DECISION DELEGATED TO HEAD OF PLANNING

Application No: H18-1047-24 **Applicant:** Mr T Bissett
Proposal: Proposed workshop conversion to dwelling, including lifting of existing roof
Location: Workshop Rear Of 9 New Road Fronting King Street Sutton Bridge
Terminal Date: 31st March 2025

Proposed Site Plan 1:250

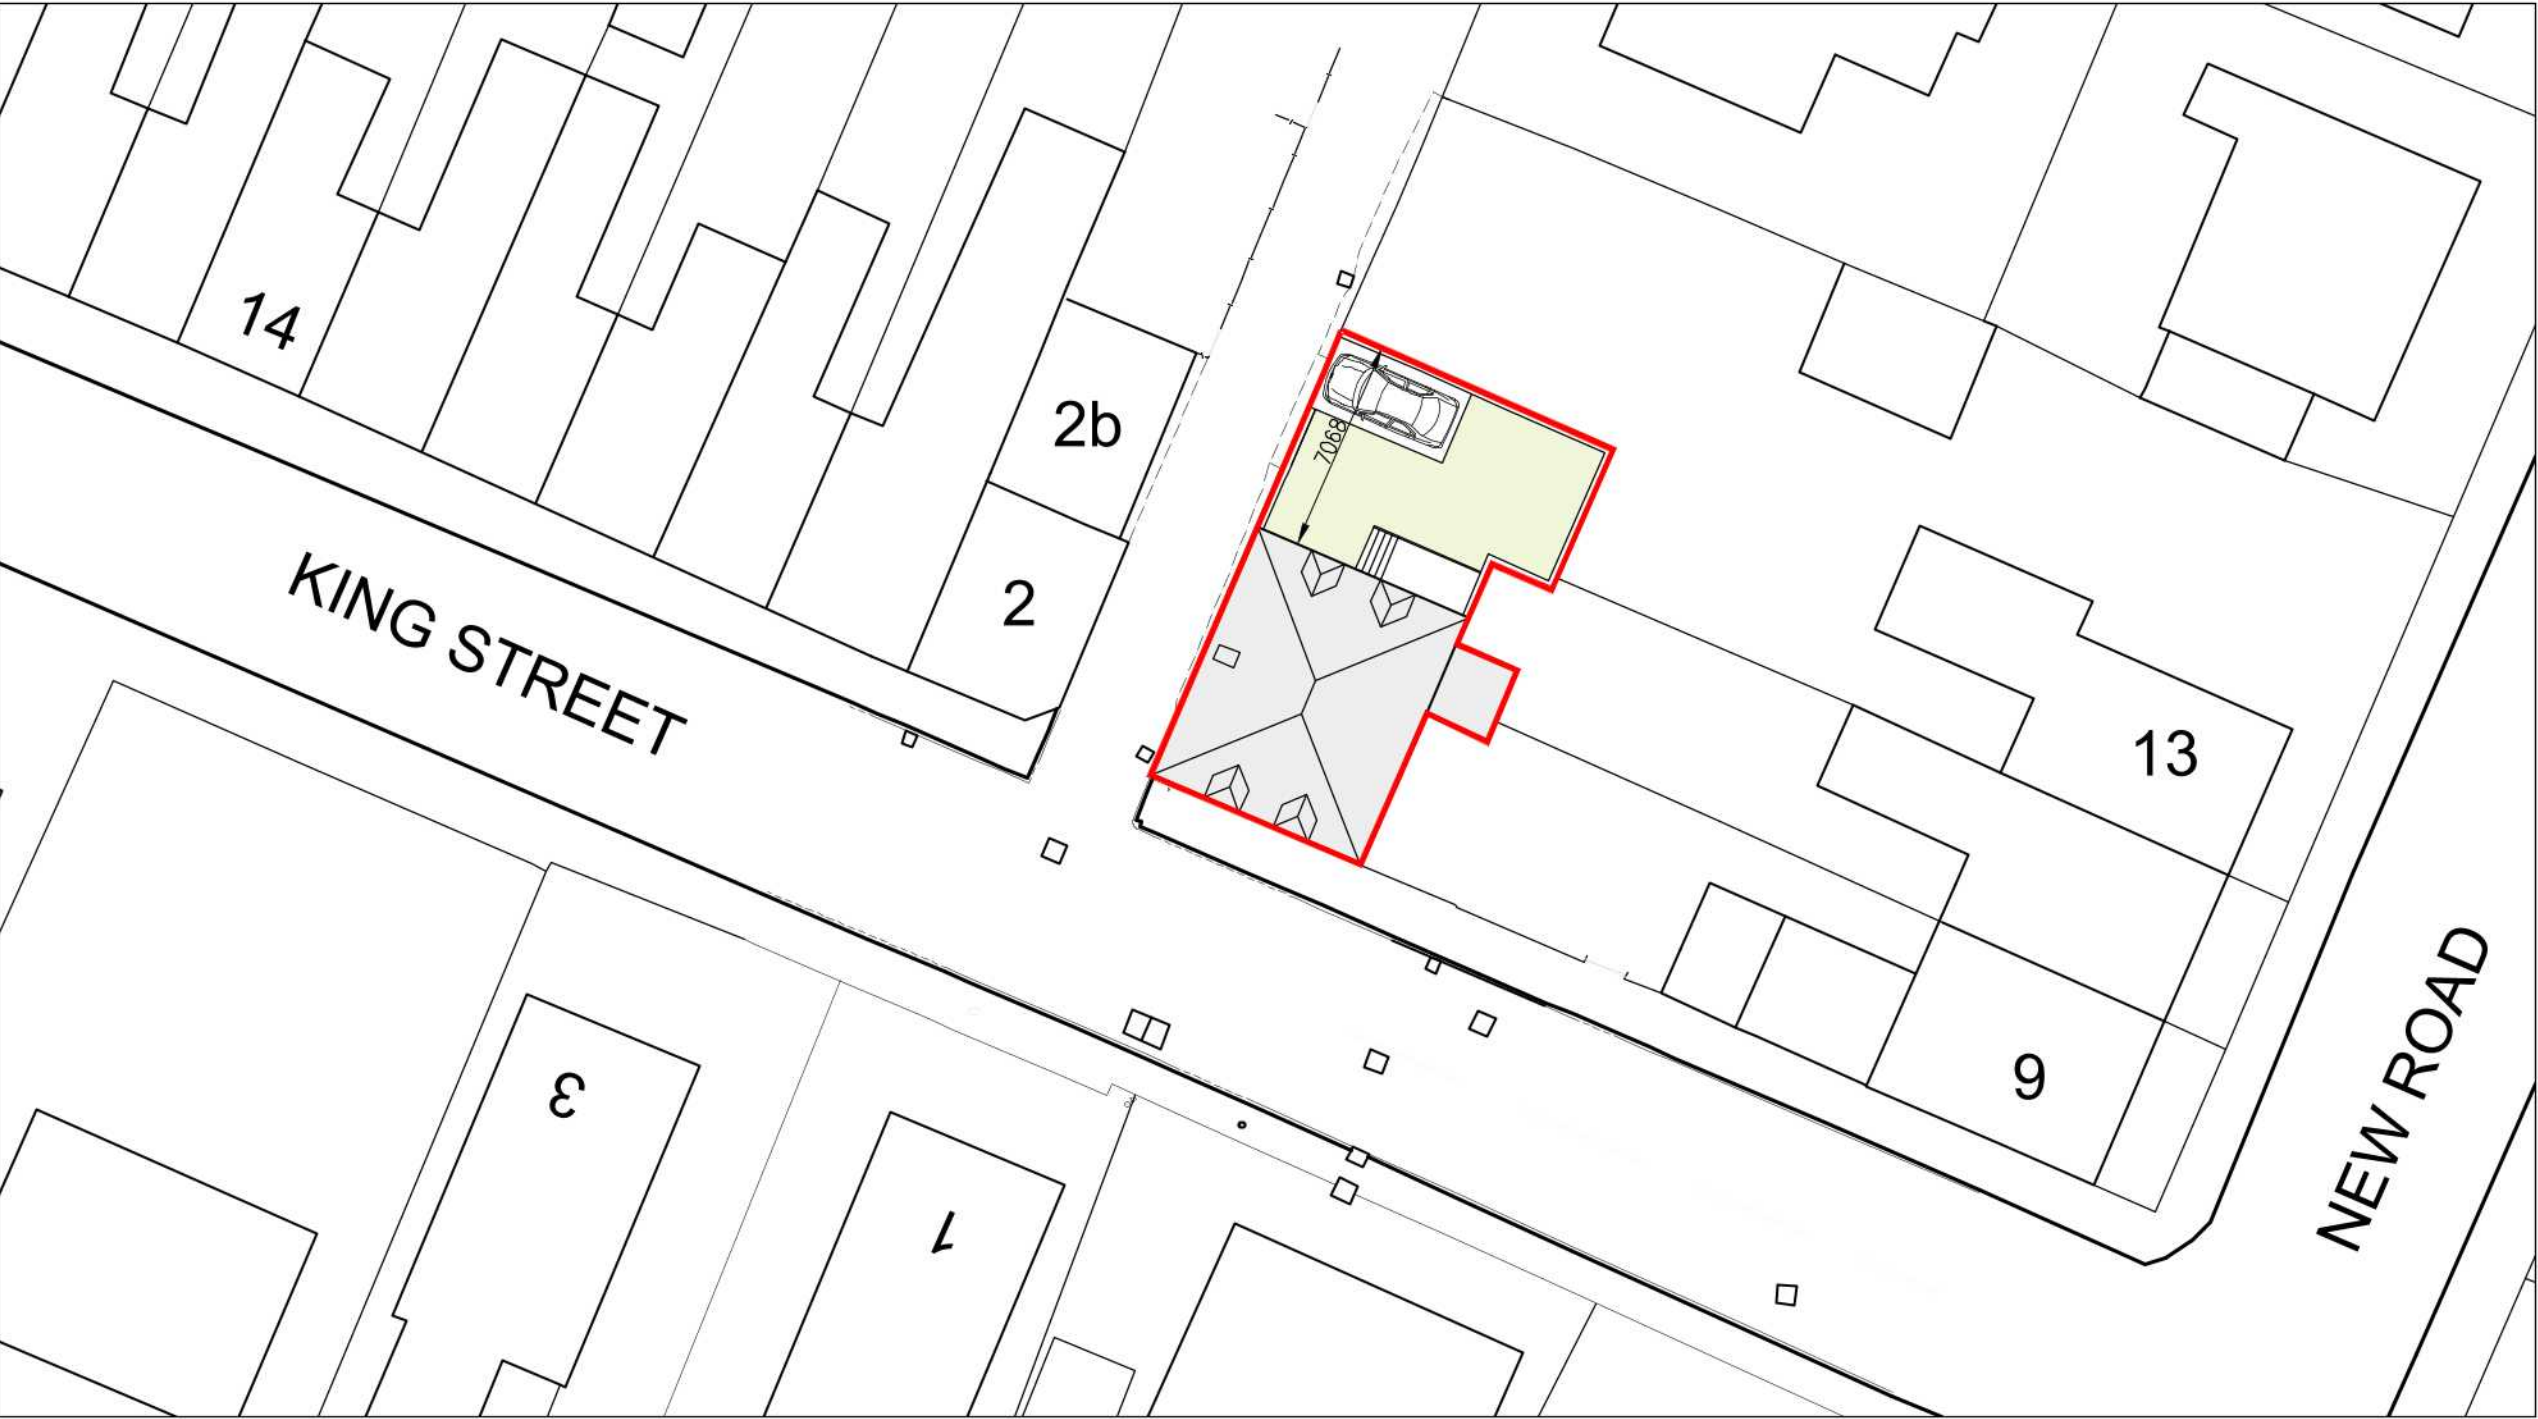
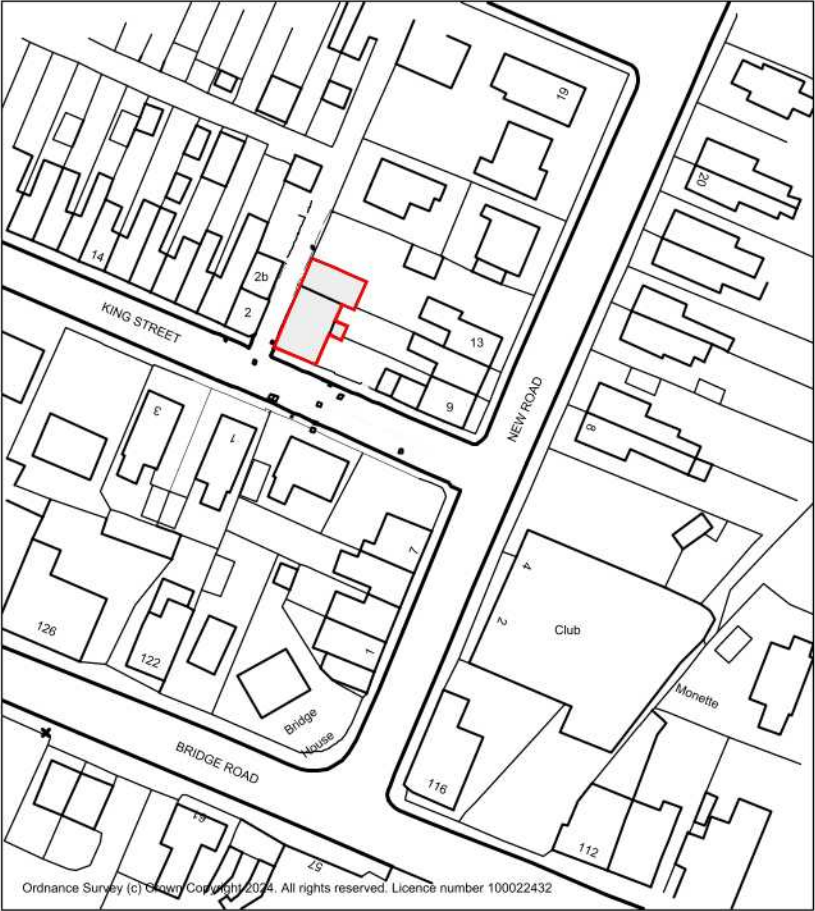
Notwithstanding this, the application site is relatively small in size and when viewed with regard to its immediate surroundings does not reflect the prevailing character in respect of the plot size or its siting amongst other independent dwellings. Given the small and contrived size of the plot, the proposal to convert the workshop to an independent dwelling would result in a somewhat cramped and contrived form of development.

The dwelling proposes three bedrooms and as such, two vehicle parking spaces are required. The small drive to the front rear of the site allows for one vehicle plus an internal garage with access via King Street makes room for a second. It should be noted that on street parking is common along King Street and New Road and would not necessarily cause harm to the highway. Lincolnshire County Council Highways were consulted and raised no objections to the application with their comments reading as follows: 'The proposal is for workshop conversion to dwelling, including lifting of existing roof and it does not have an impact on the Public Highway... Sufficient parking provision can be accommodated within the development'. Following on from this, in relation to Amendment 1, their comments raised no further comments of importance.
